From: Laura Gibbons
Sent: 20 December 2018 12:22
To: Planning.Responses
Cc: Anita Gardner
Subject: RE: Planning Consultation on WA/106/18/DOC

Engineers Comments Regarding Surface Water Drainage

APPLICATION **WA/106/18/DOC**
NO:

Site Address: Progress Garage Yapton Lane Walberton BN18 0AS

Drawing Title: Engineering Layout - Drainage, Levels and Contours

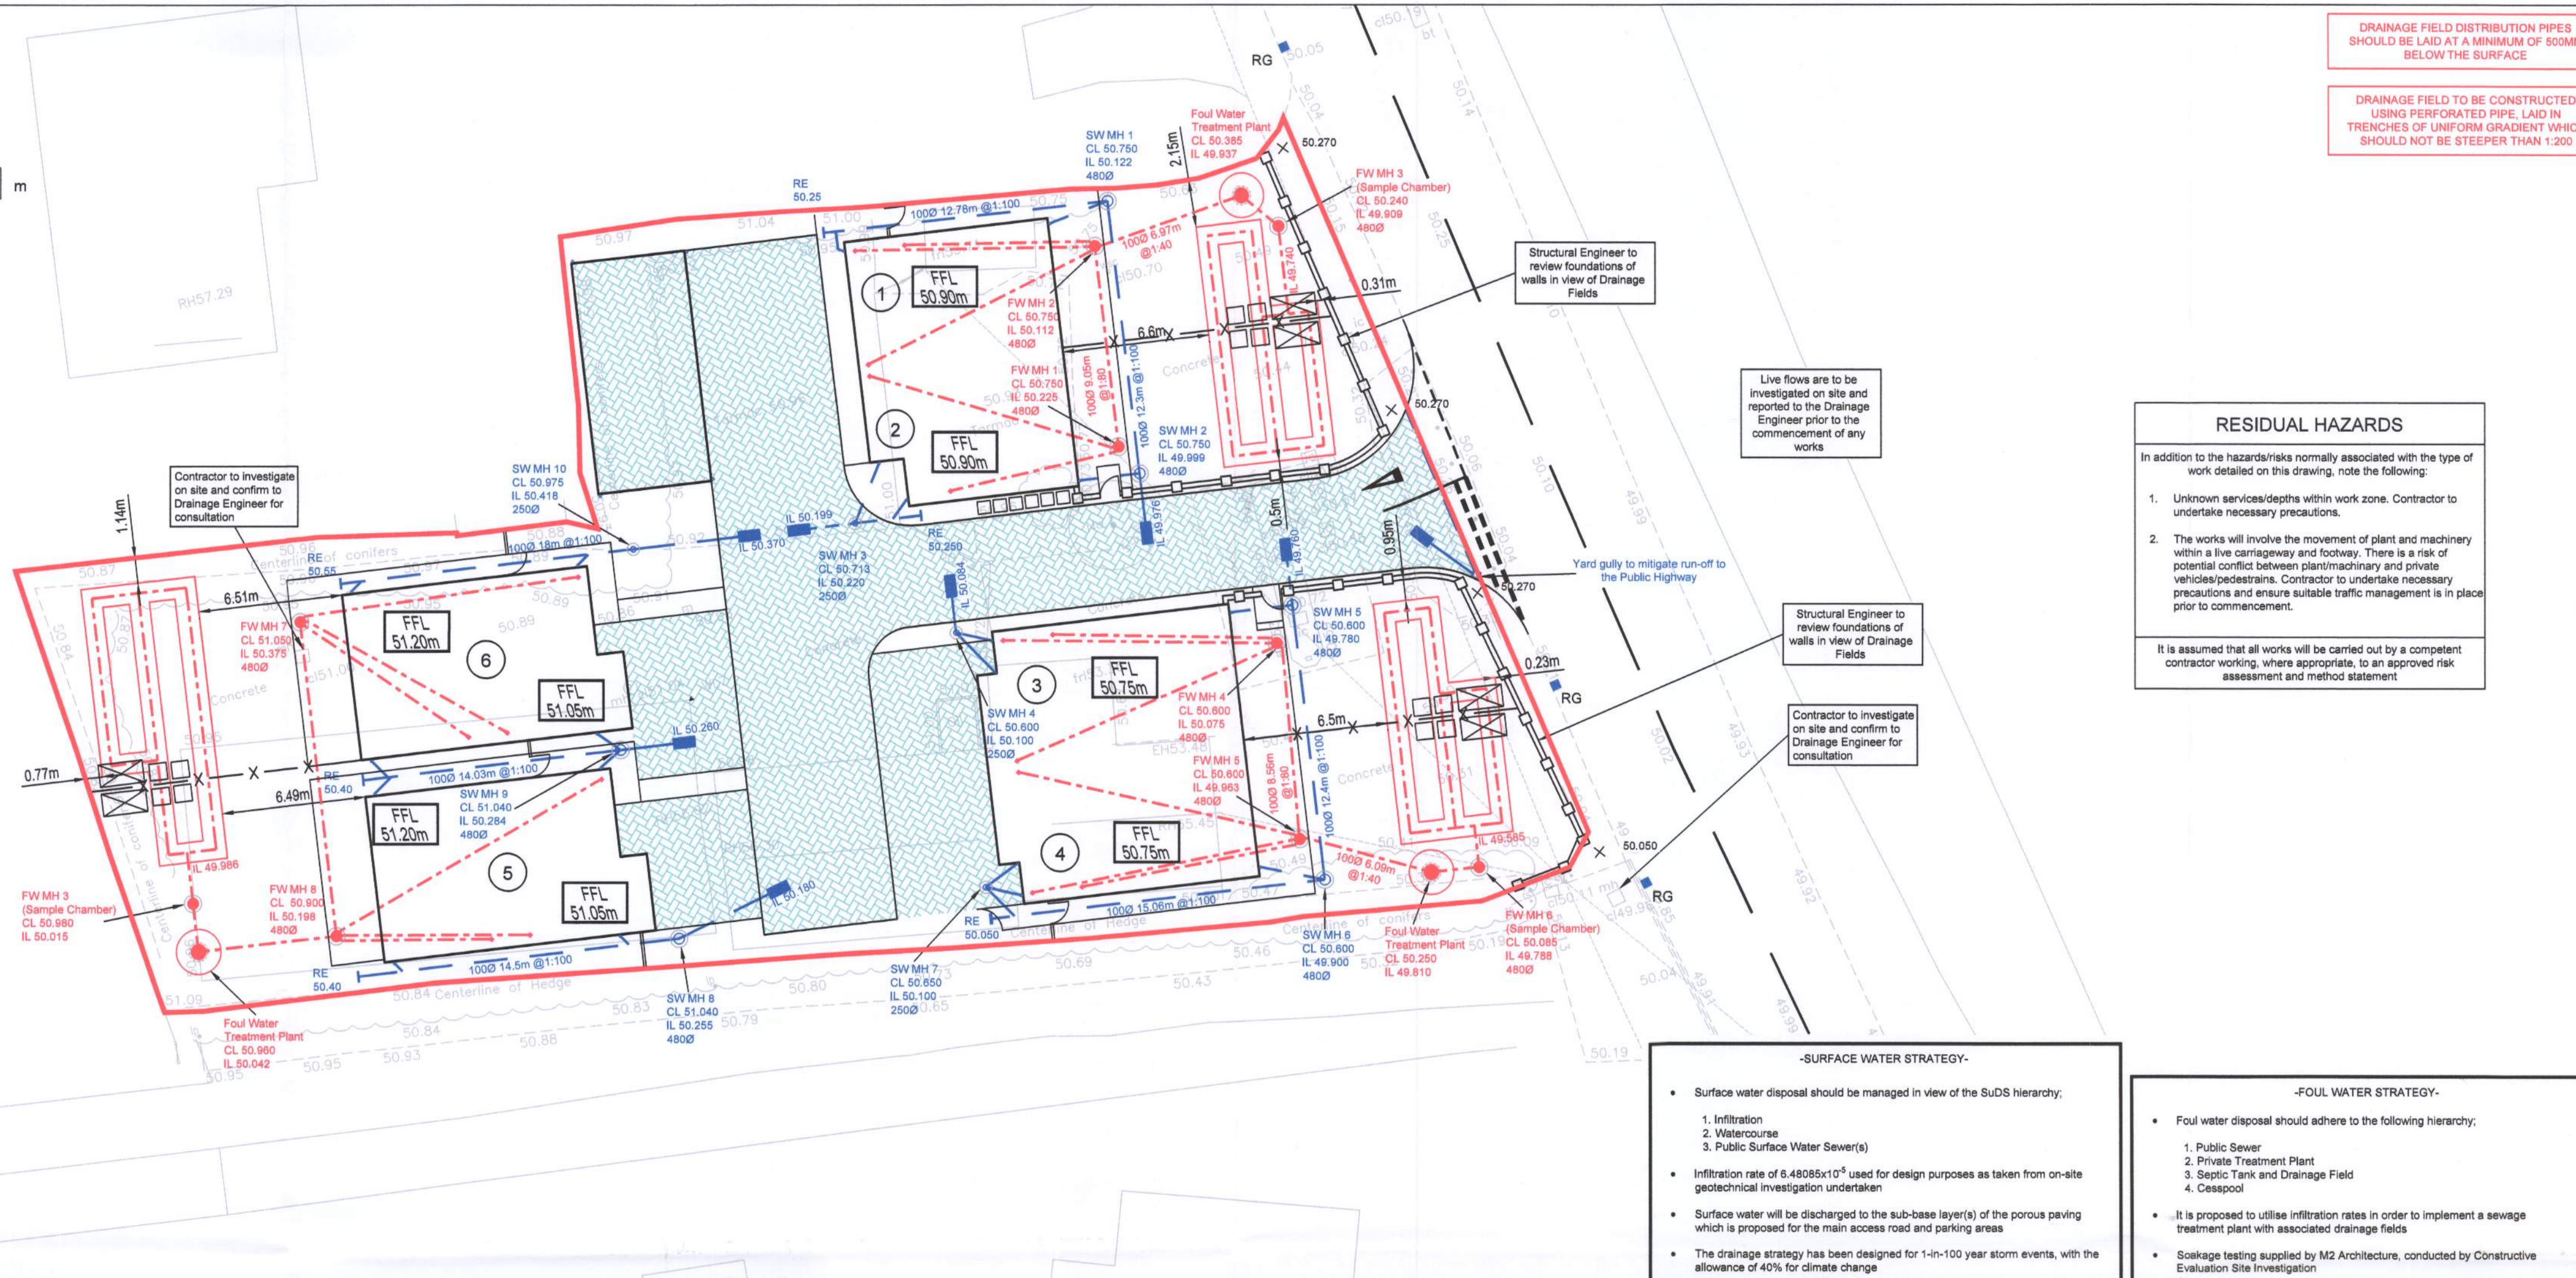
Groundwater monitoring has not been completed October to March inclusive as is required for a development of this size.

No winter infiltration tests have been provided.

No plans, calculations, or construction details have been provided.

Winter infiltration testing and groundwater monitoring needs to be completed. Following this full detailed calculations, plans and construction detail drawings should be submitted.
